Application for a non-material amendment following a grant of planning permission.

Reserved matters (Appearance, landscaping, layout and scale) submission of details pursuant to conditions 2, 3, 5, and 15 of Appeal Decision Ref. No. APP/Q4625/13/2192128 (Outline Planning Application Ref. No. 2012/1627) for the erection of 200 No. dwellings and associated highway infrastructure, drainage and open space works.	
Reference number:	PL/2018/01828/PPRM

TG-MAT-01 MATERIALS LAYOUT
COTTAGE - 816103 - 5HOC401TH

-COTTAGE - 816103 - 5HOC401TH REV C
-TG-MAT-01 MATERIALS LAYOUT REV K

Drawing Title
5HO HONEYBOURNE- BUILDING REGS 2013/
SALES 2018 FRONT ELEVATION
COTTAGE STYLE WITH TILE HANGING

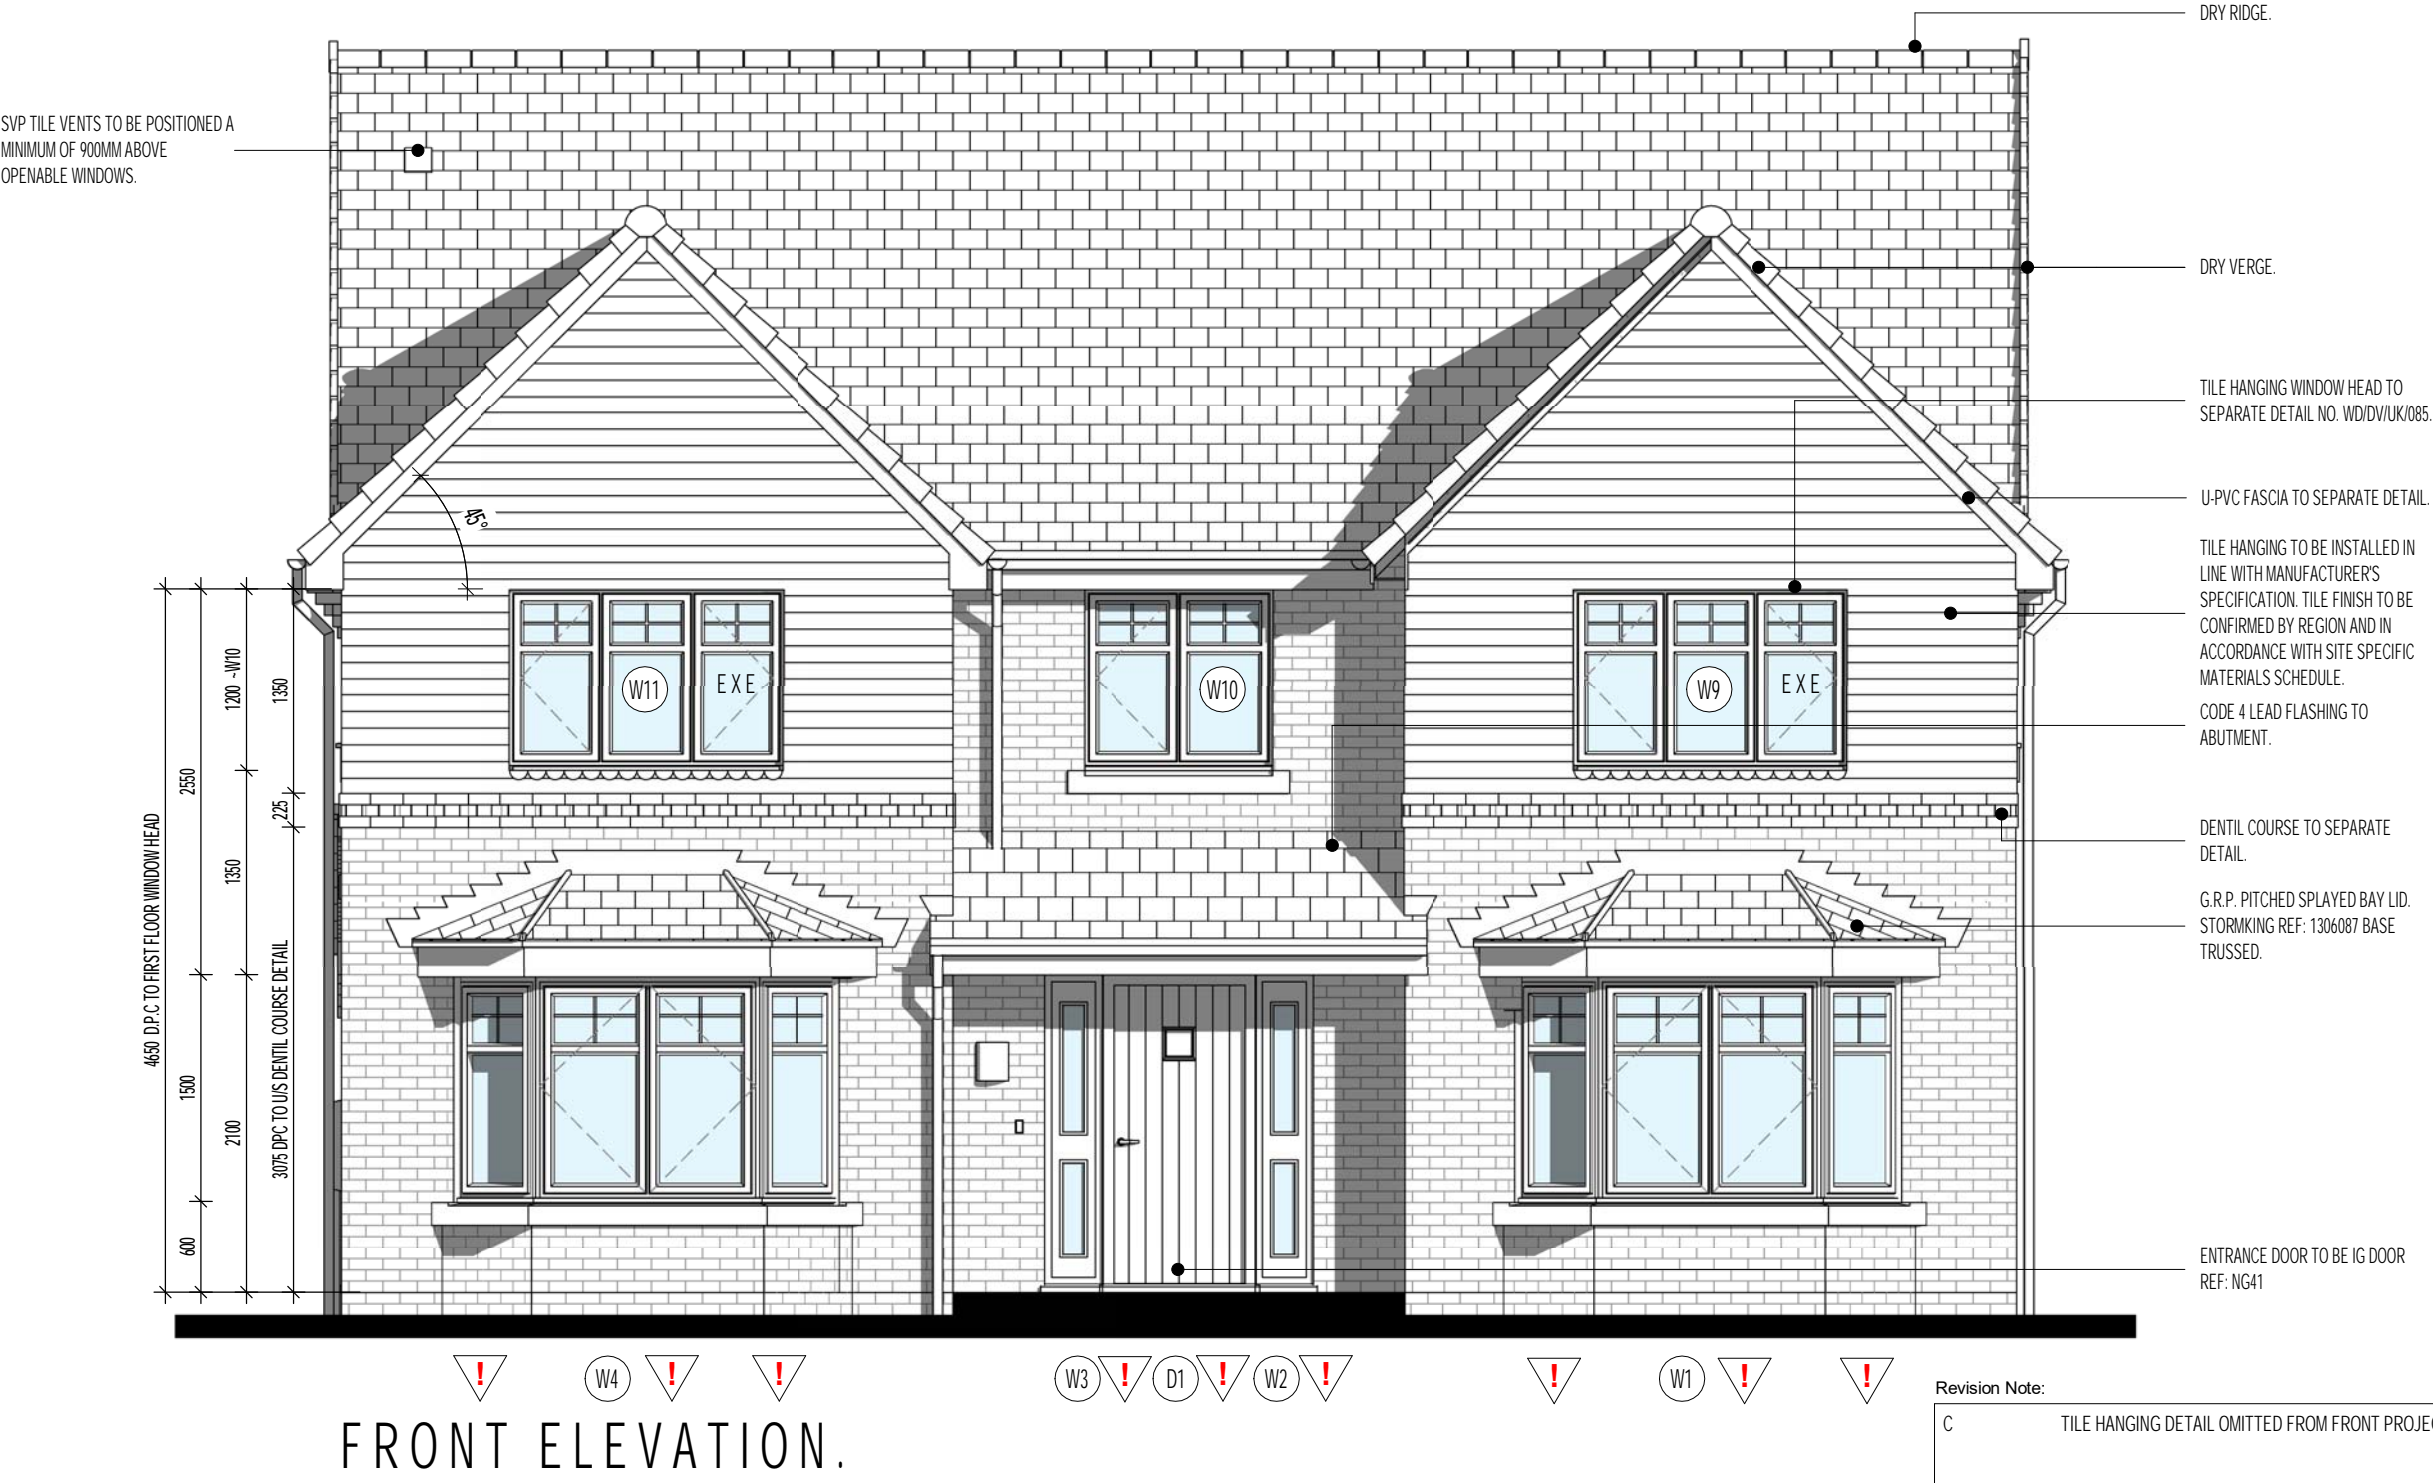
- Housetype 5HO scalloped tiles have been removed from the tile hanging type due to supply issues.
